Your Ref: OWQC17483
Our Ref: EP/11/18/HH
Please ask for:
Mr M Jones

2nd March 2018

Erect Cabin in rear garden
98 North Lane East Preston

PROPOSED
SITE PLAN

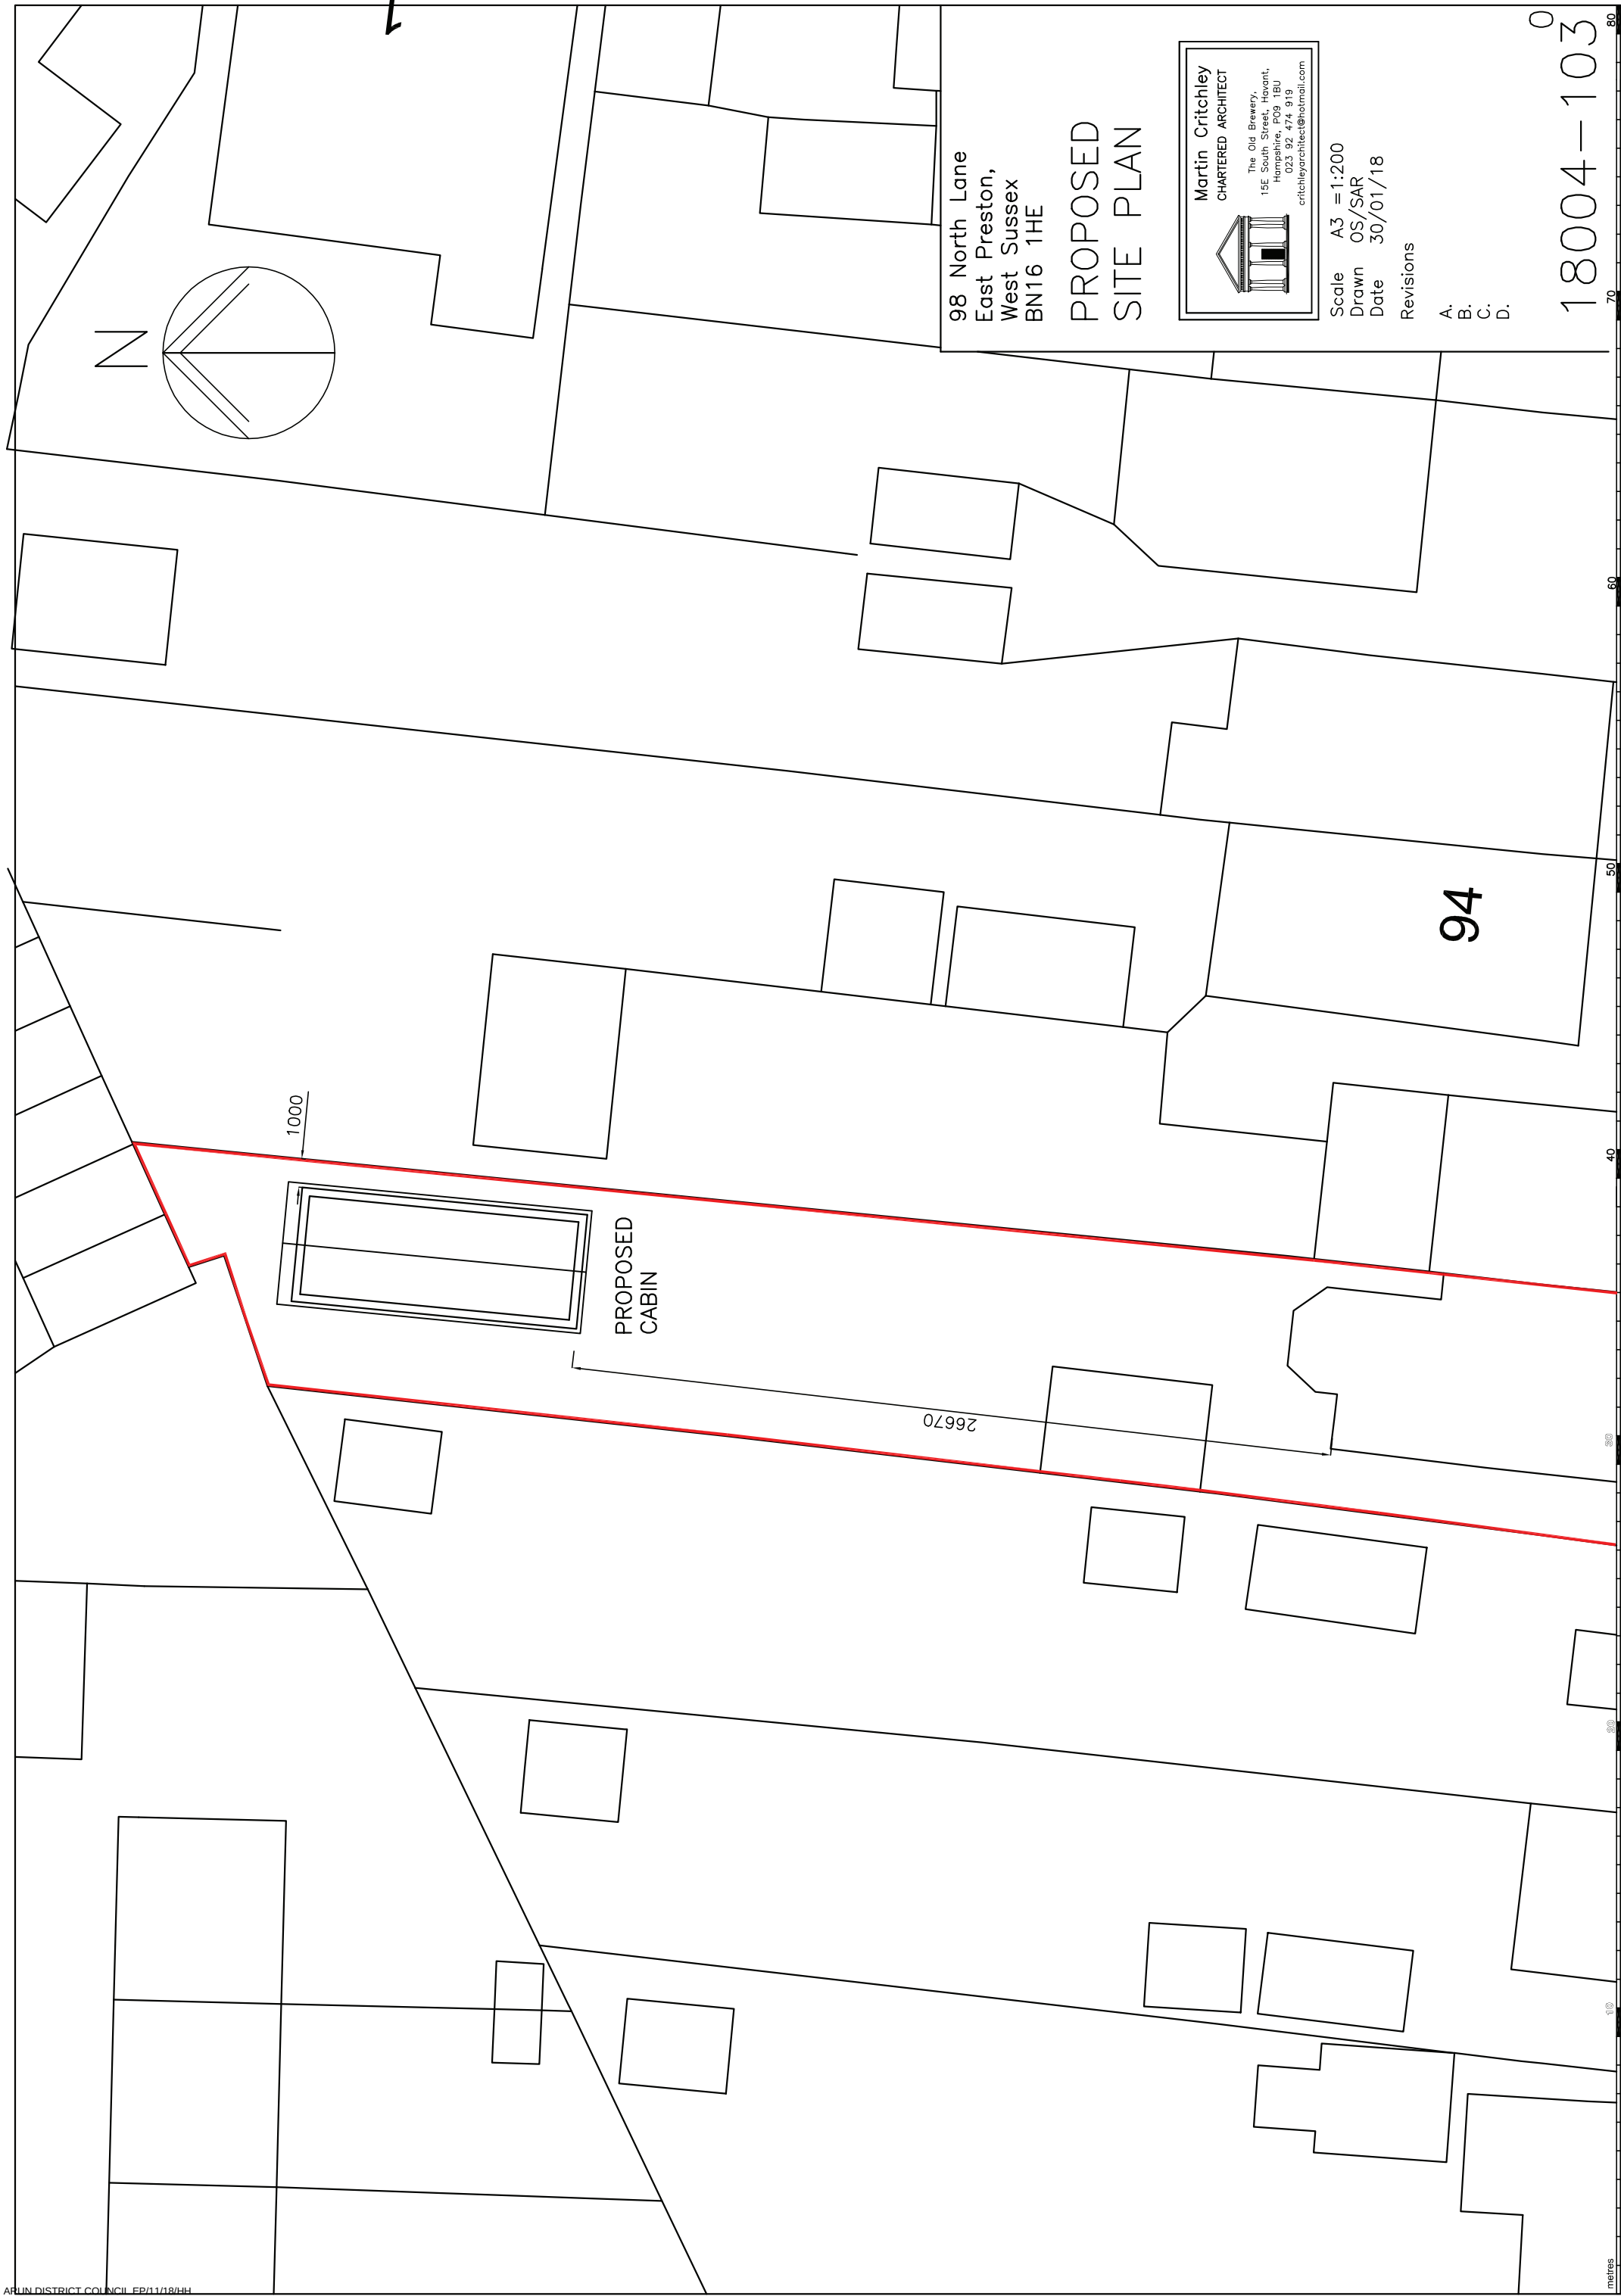
The committee agreed to object to this Application as there is no indication given as to what the cabin will be used for. Until this is resolved this council will continue to object to the cabin. The committee was also concerned about the scale of the cabin, feeling this to be possibly unneighbourly.
